Wilcannia Weir Replacement

Outcomes report

**Engagement with Wilcannia Aboriginal Communities
to review the Environmental Impact Statement for
the Wilcannia Weir replacement project**

Figure 3-1 Concept landscape plan for the community river place

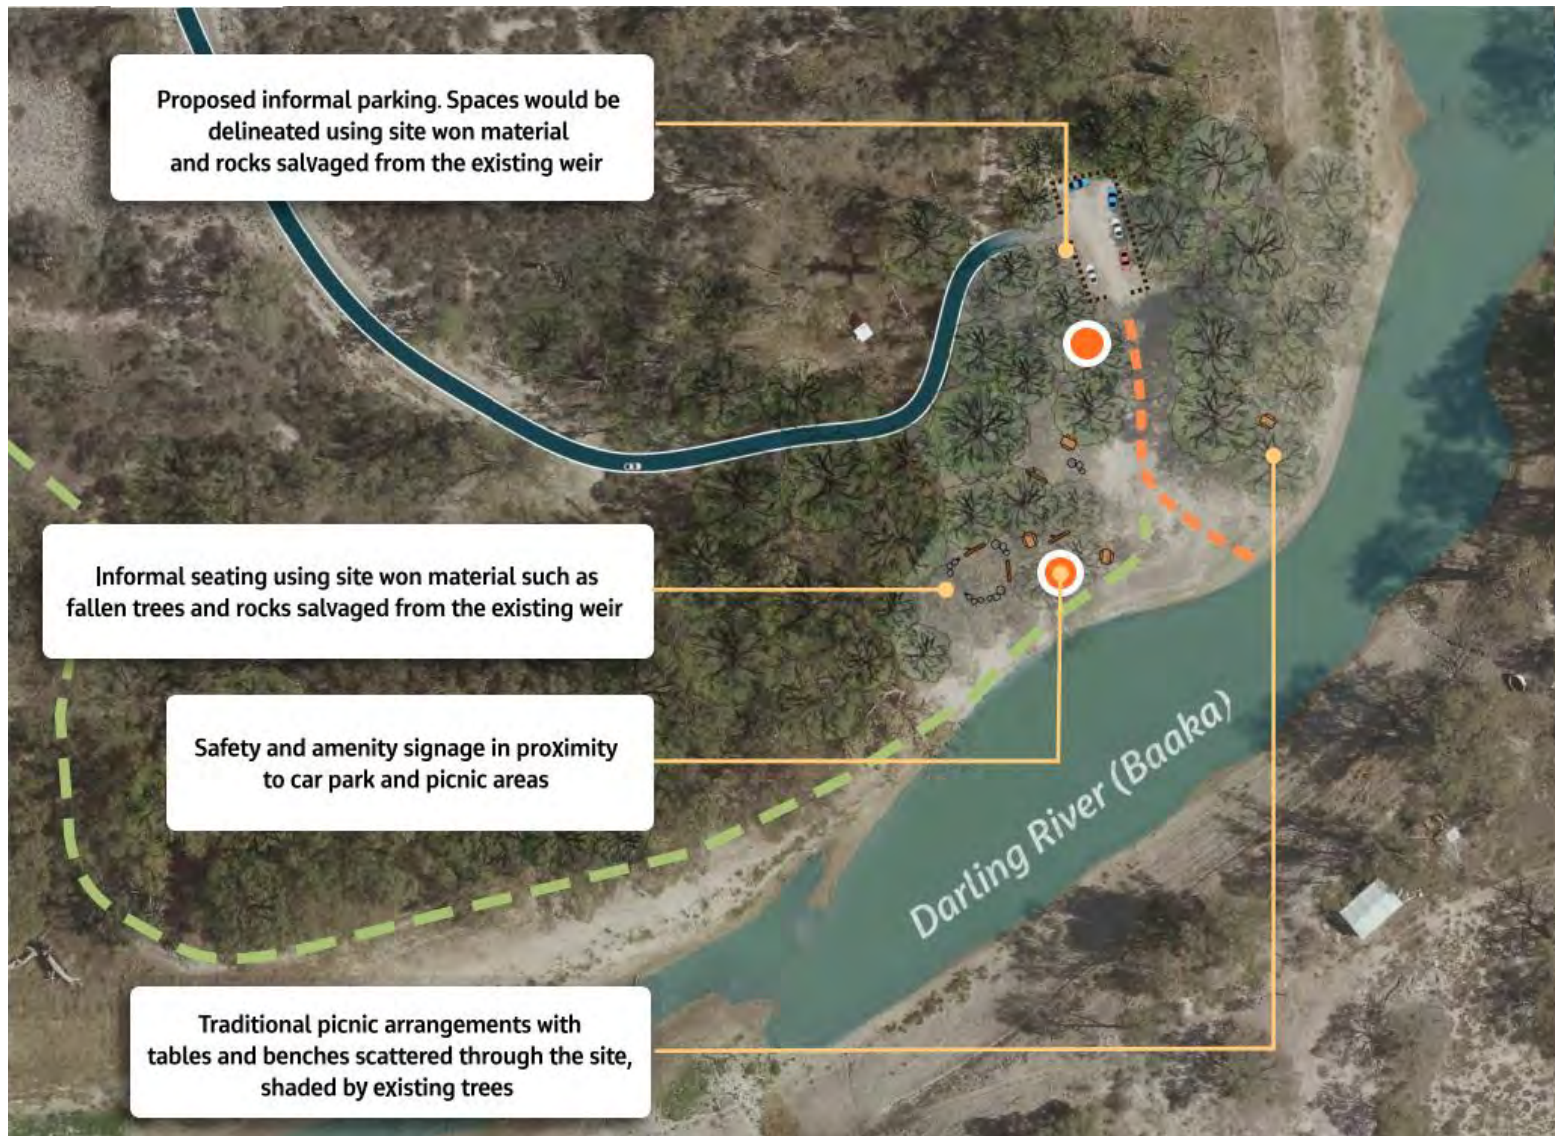
3.1 Community River Place: Participants were positive about the creation of the Community River Place as a recreation area and point of interest for visitors to Wilcannia. However, all participants expressed their wishes for facilities and amenities additional to those indicated in the EIS and associated documents. Additional facilities and amenities identified by participants during discussion included the following:

- A playground for children
- Seating and tables with shade and rain protection
- Toilets
- BBQs
- Fire pits
- Bicycle stand
- Drinking water
- Rubbish bins

- Boat ramp
- Floating pier

"We thought the River Place was going to be close to the weir."

6.7 Community River Place and flooding: Several participants also expressed concerns about the height of the Community River Place and access to the area in general when the river water level is high.

"What will happen when it floods? Will the Community River Place be under water?"
